Wyre Planning
Wyre Council
Civic Centre
Breck Road
FY67PU

Objection to Planning Application 20/01296/OUTMAJ.
Alternative reference PP-09342441
Outline application for up to 41 dwellings (Land Off School Lane, Forton)

PROPOSED SITE PLAN:
 CLIFTON HOUSE FARM, SCHOOL LANE, FORTON, PR3 0AR

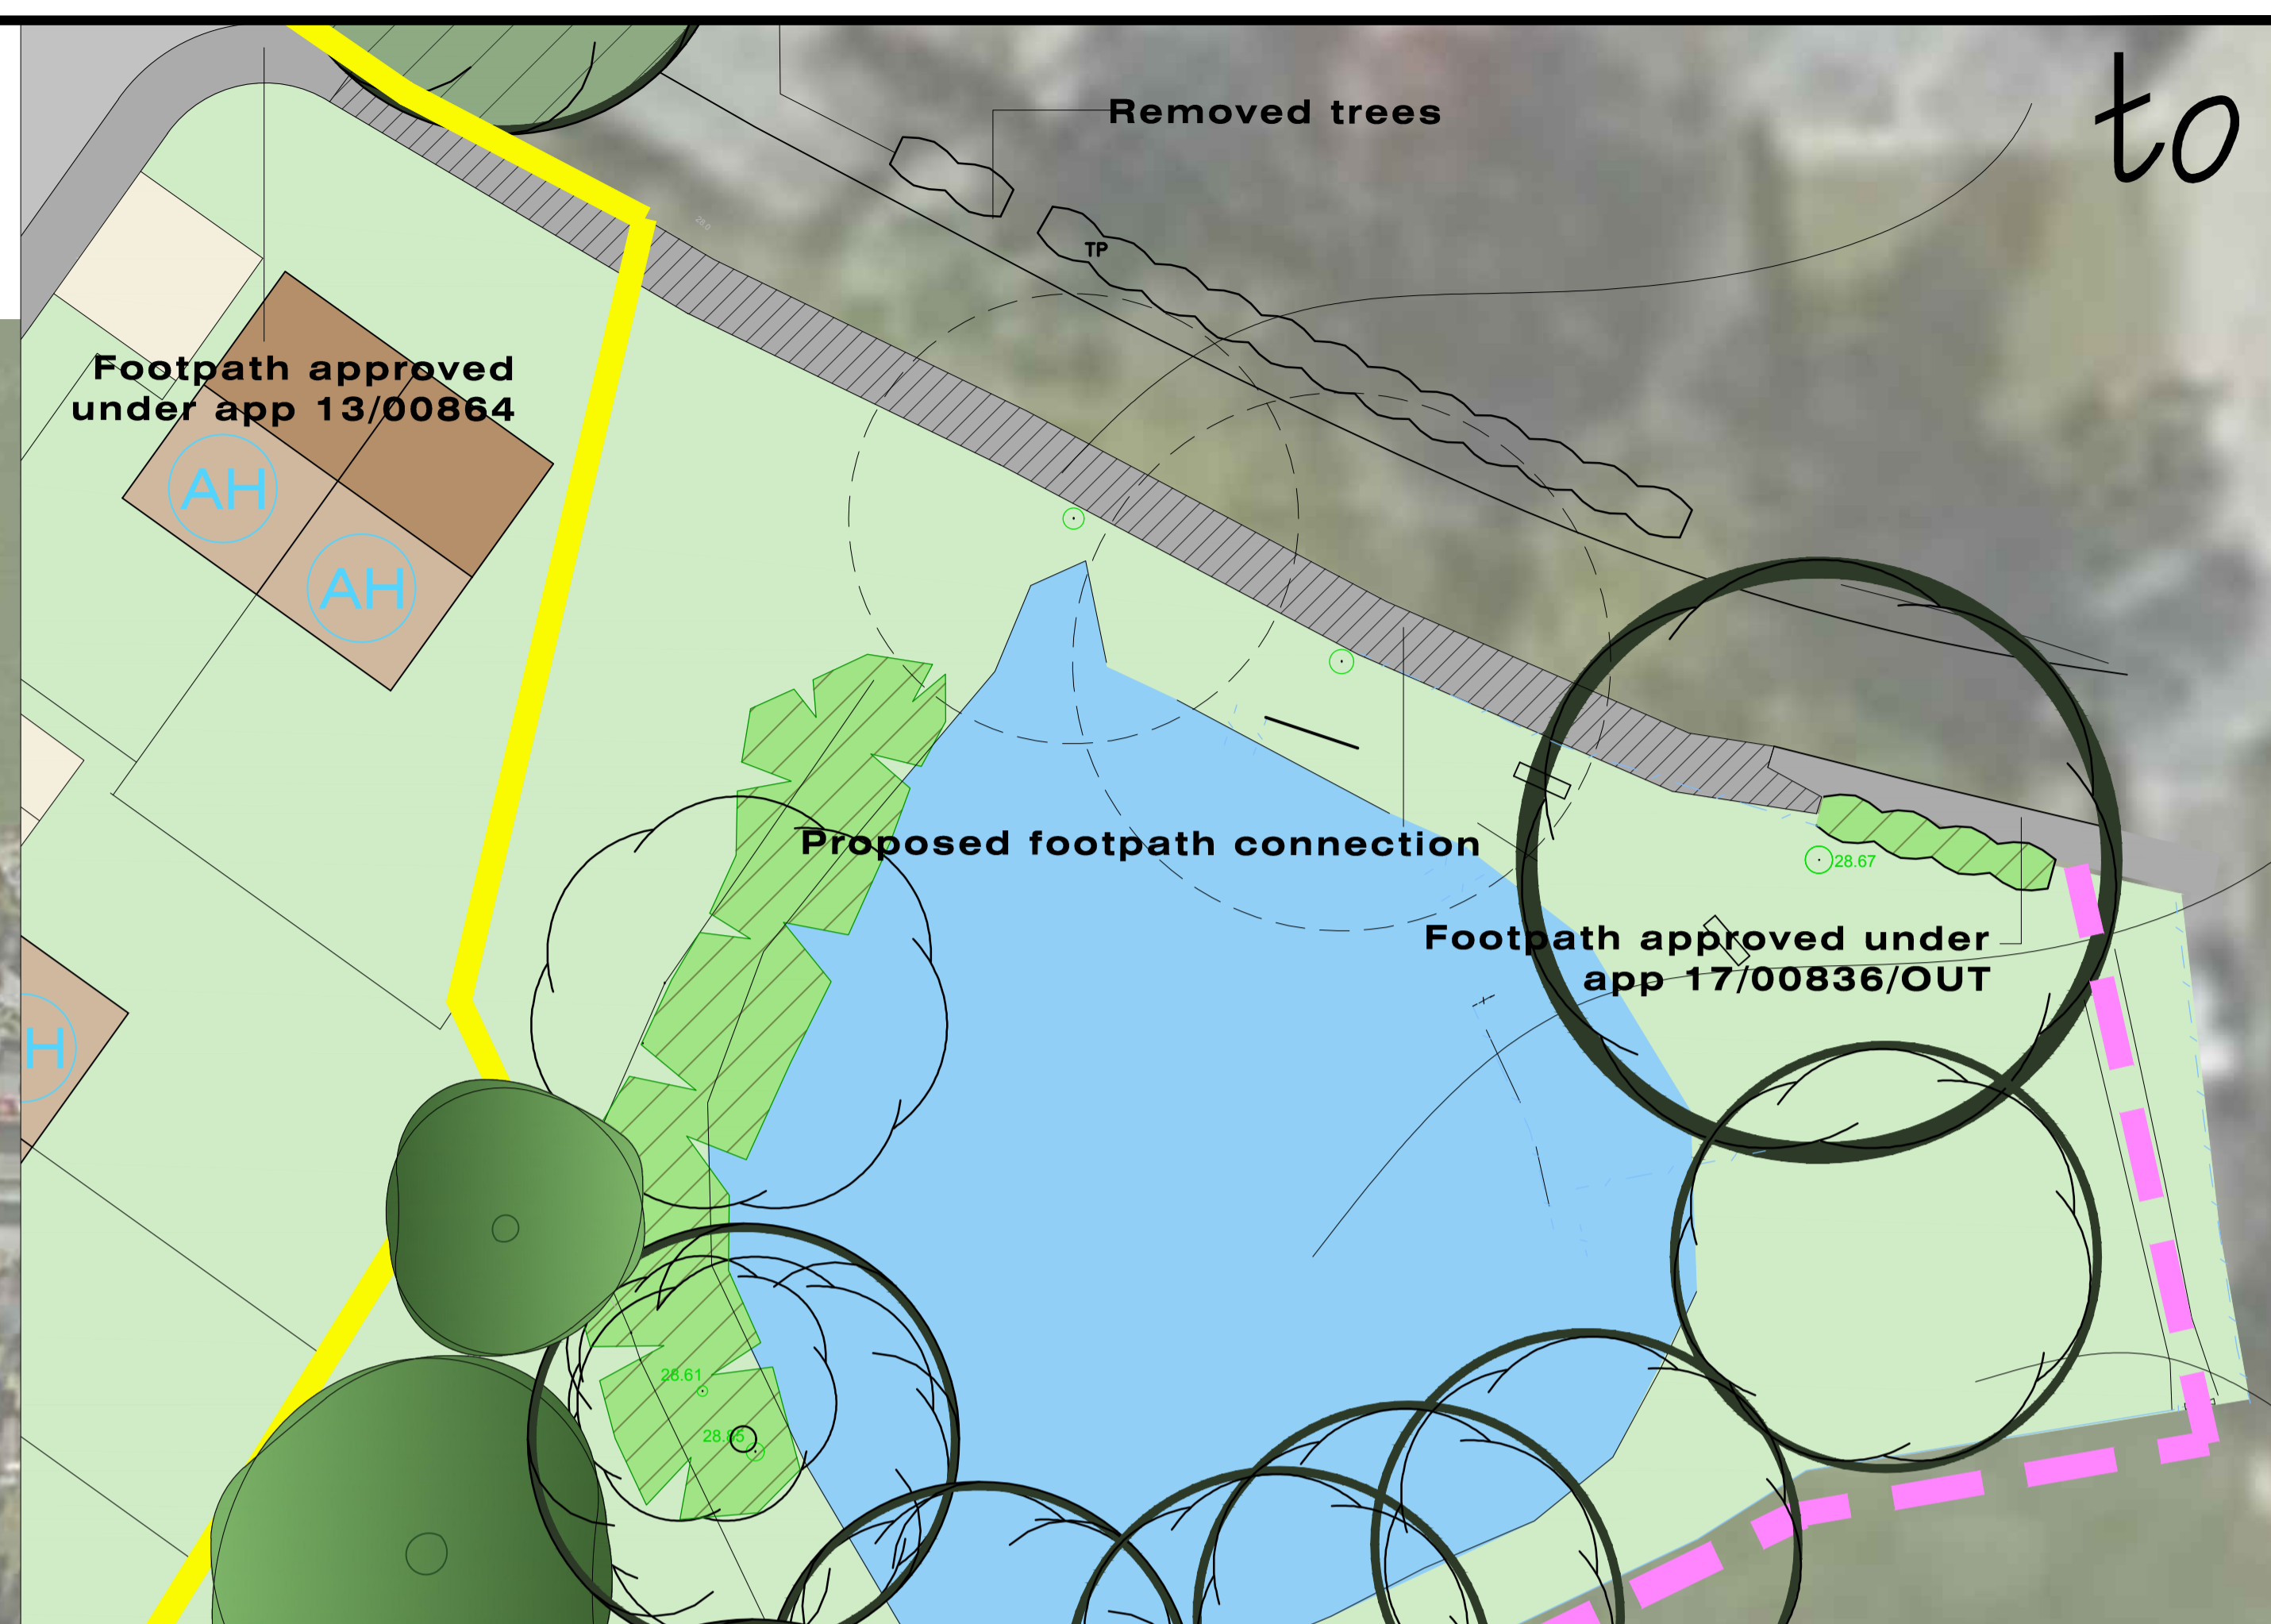
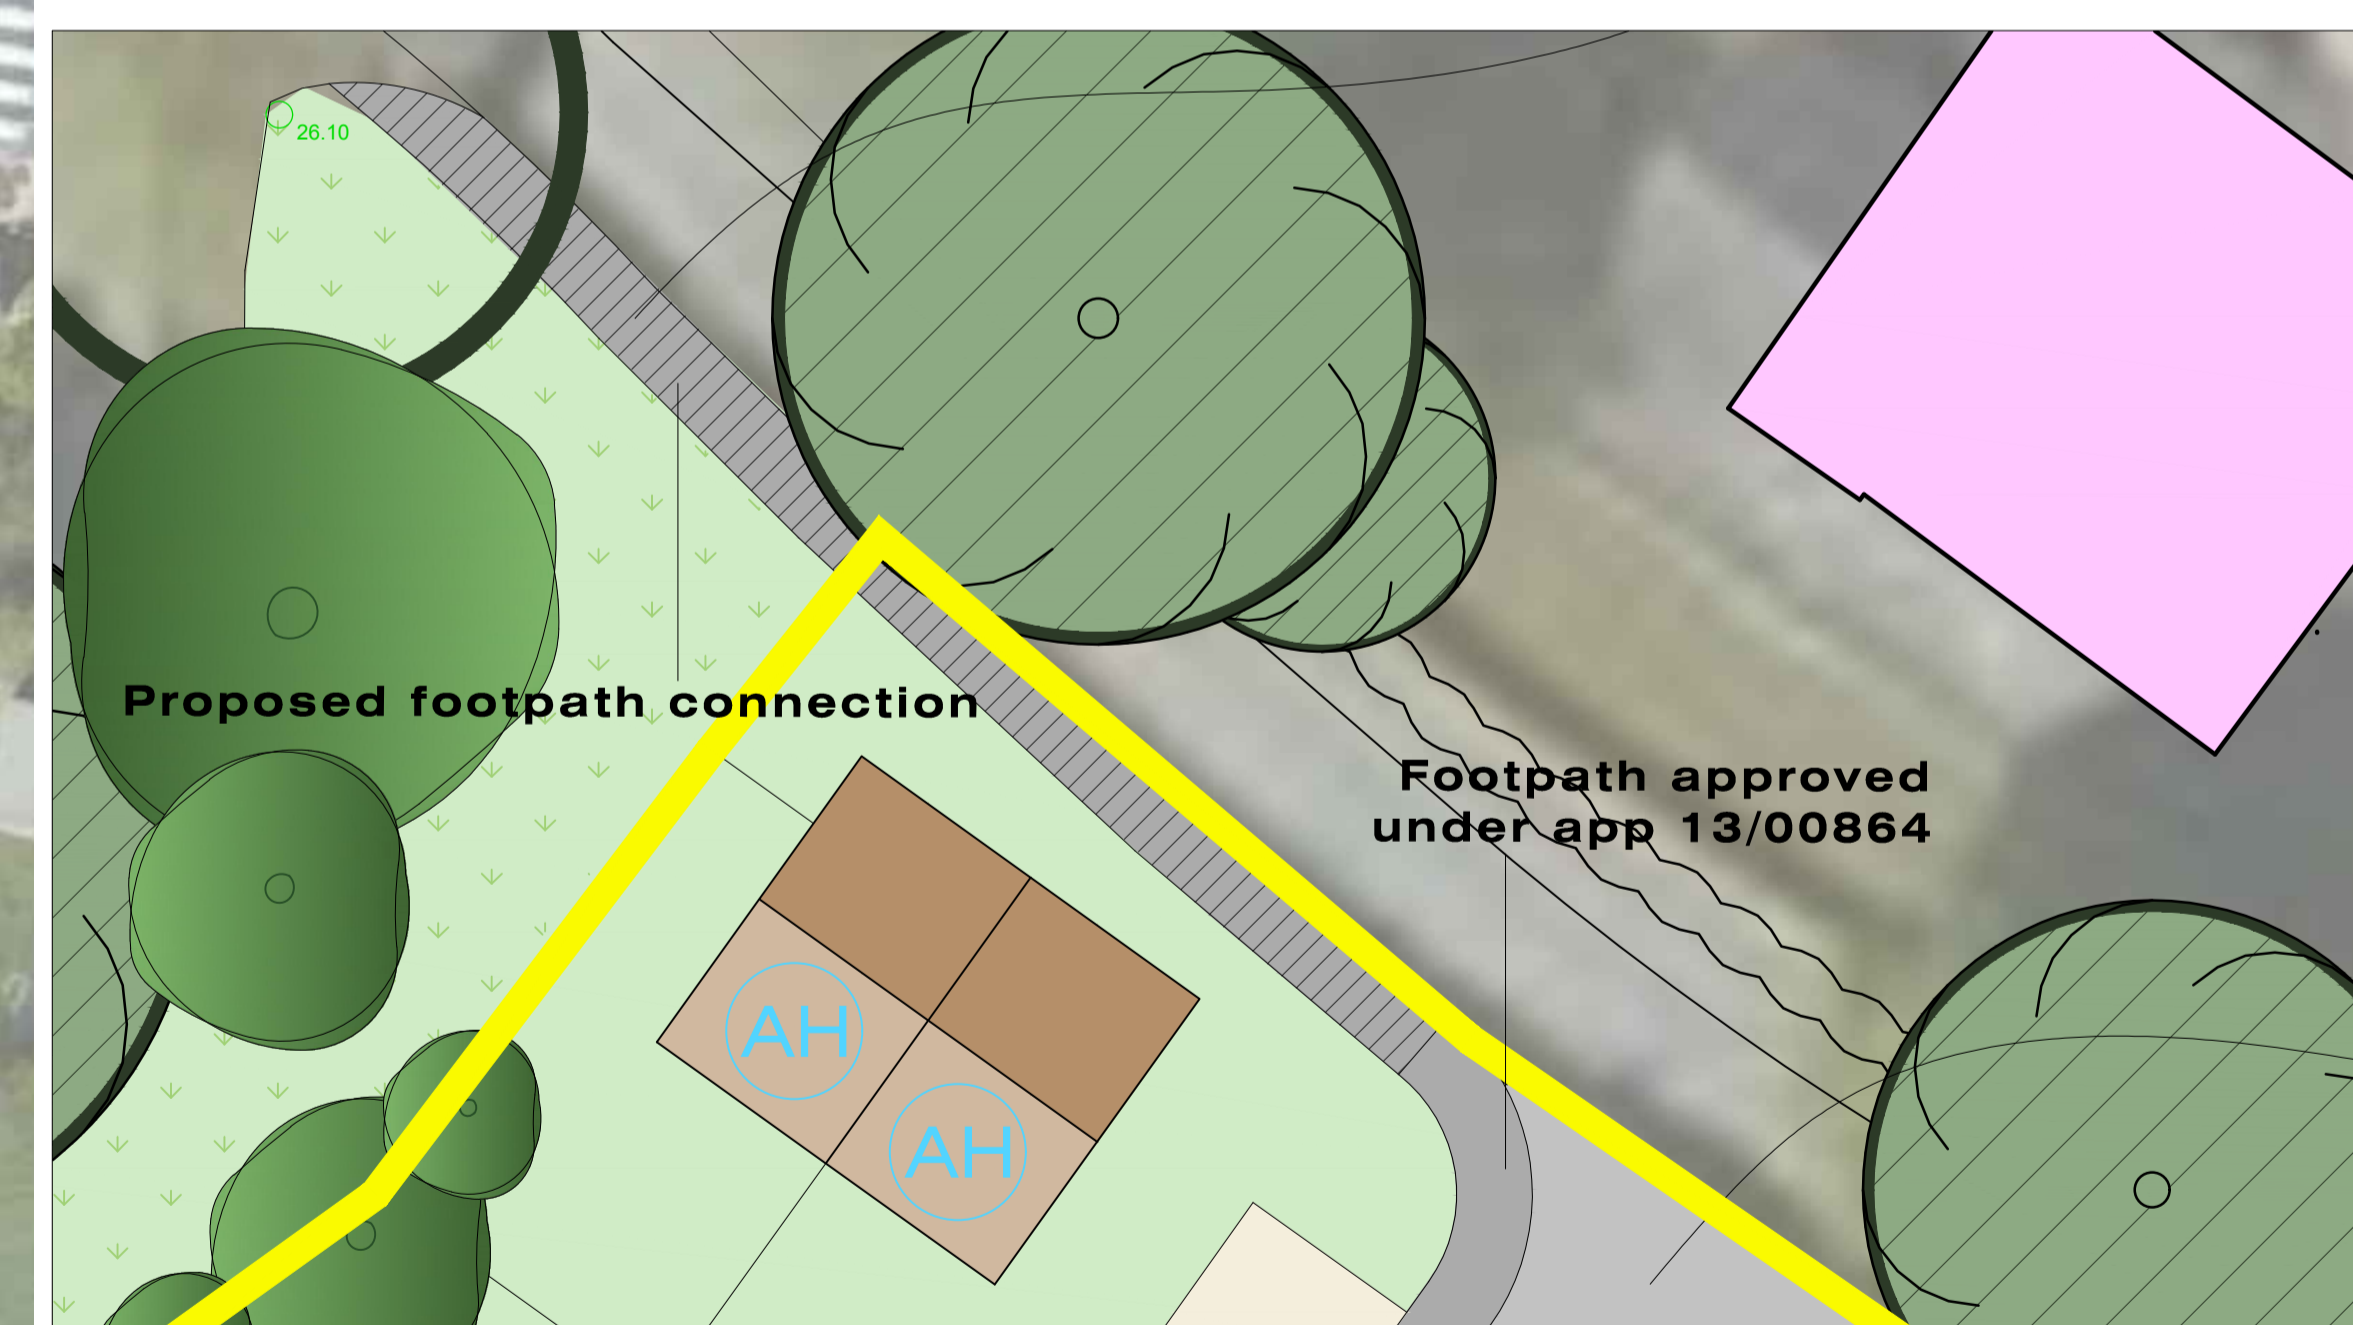
5. Impact on local wildlife, there is currently a small pond and drainage ditch that is not marked on the proposed plans, I know that there are many wild ducks, and I am sure plenty more wildlife that use this pond and ditch to nest on and around during the day and night. These ducks currently fly between a few small ponds in the local area one of these ponds is the pond marked on the map between the school and chapel close. I feel the disruption and pollution would drive these wild animals out of the area where they would over-populate somewhere else and likely not survive further reducing the already declining population of wild ducks.

8. I think there should be some attention paid to who's responsibility it would be to maintain the area behind the 5m tall fence marked on the proposed site plans within the 65m of the cricket square I think it would be unfair of the cricket club to be assumed to take responsibility of this area and I do not think any developer will take responsibility of this area either. My concern is this area will be left and will become overgrown and encourage vermin such as rats to move in on the area. This also should apply for the shared open space marked on the plan.
